Application No: EP/53/22/HH
Site Address: 38 Hillview Crescent East Preston BN16 1RQ
Description of works: Hip to gable loft conversion with rear dormer.

Thank you for your internet representation made on 14th June 2022 which has been recorded as an objection with the comments as follows:

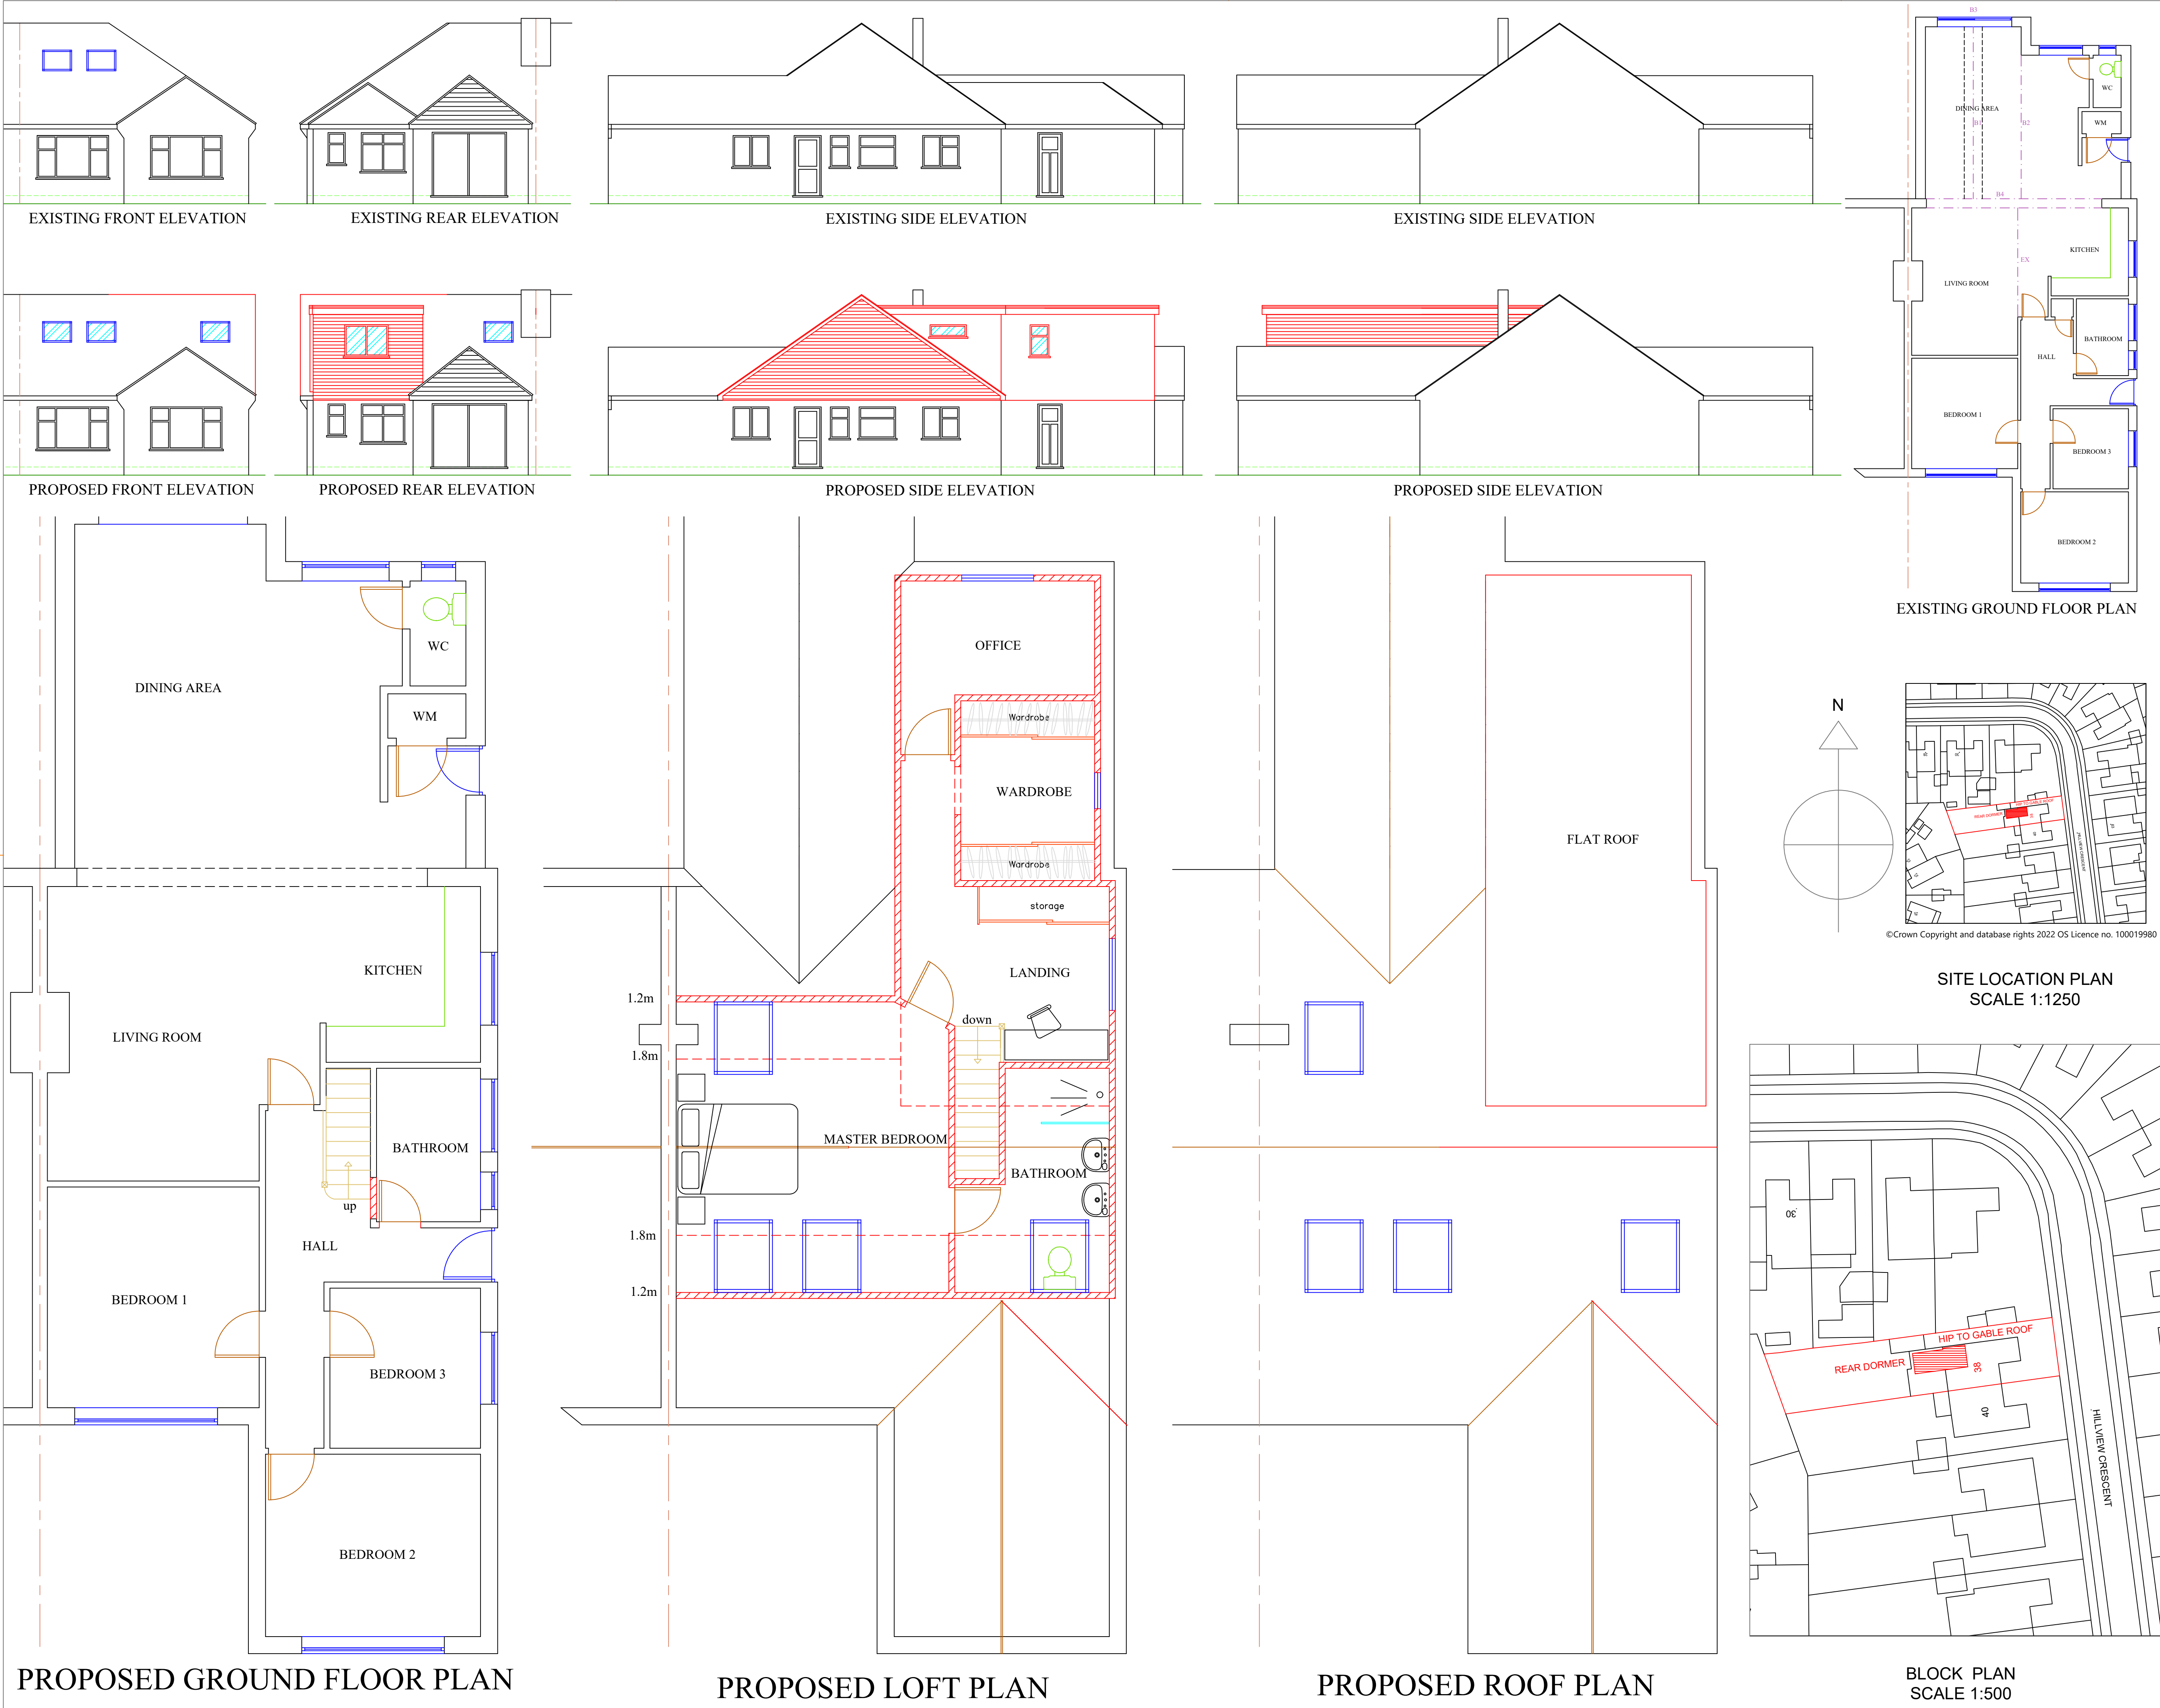
Living on the north side of 38 Hillview Crescent and directly facing it from the rear of our property, our view from our lounge, kitchen and garden will be of the large area of brick or cladding used in the gable end, and the very long dormer.

We have loft conversions in our road but these are nearly all gable ends with normal size, full-width dormers at the rear of the properties.
